**The Sizewell C Project, Ref. EN010012**

**Issue Specific Hearing 11 (14 September 2021)  
– (ISH11) Flooding, Water and Coastal  
Processes.**

**Suffolk County Council Registration ID Number: 20026012**

### Post Hearing Submissions including written summary of Suffolk County Council's Oral Case

Plan of the surface water flood risk for properties on Abbey Road, Leiston

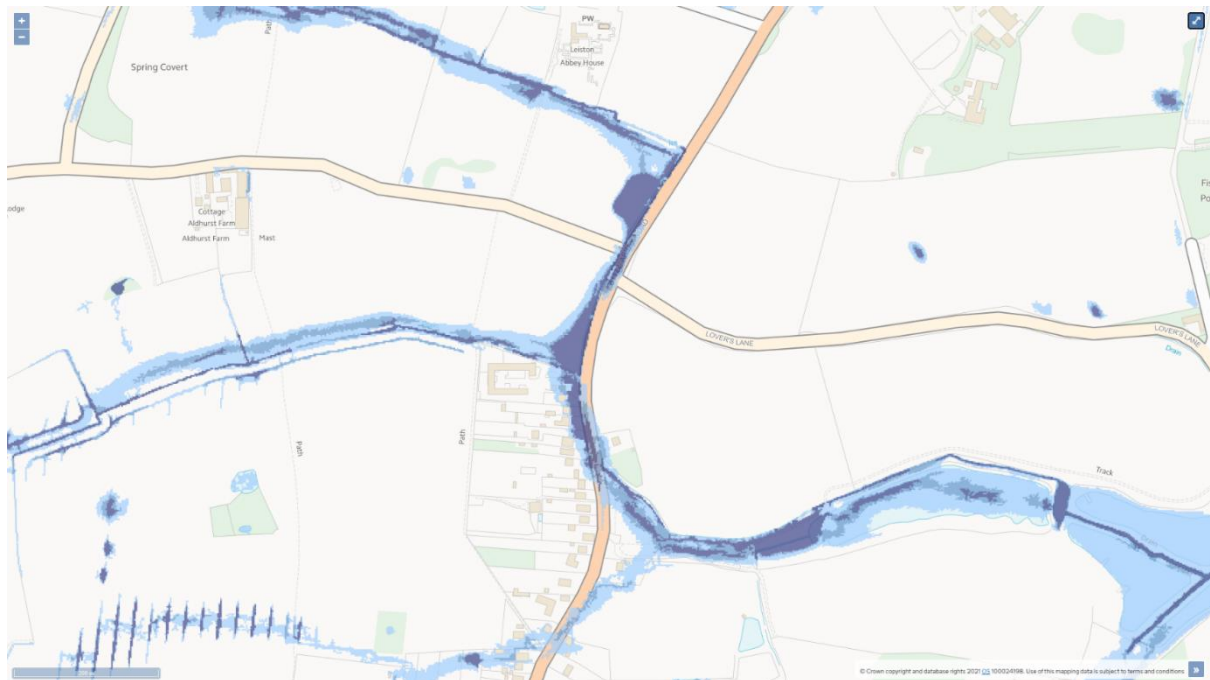
<p>The Leiston SWMP identifies that surface water would flow over Lovers Lane during 1:100+40% and should therefore be considered the worst-case scenario, not the fluvial flood risk that the Applicant has modelled. An absence of detailed assessment should not be seen or used as justification to not design for the worst-case scenario.</p> <p>SCC are willing to provide the Applicant with the model used for the Leiston SWMP. The Applicant could use this model and supplement it with more refined information that they have in relation to the Lovers Lane culvert and the upstream watercourse to improve the reliability of the model. However, in the absence of more detailed modelling, SCC's position is that the bridleway should be at the same level as the existing road (understood to be 3.11m AOD estimated from LIDAR data), to ensure there is no increase of surface water flood risk to the bridleway.</p>
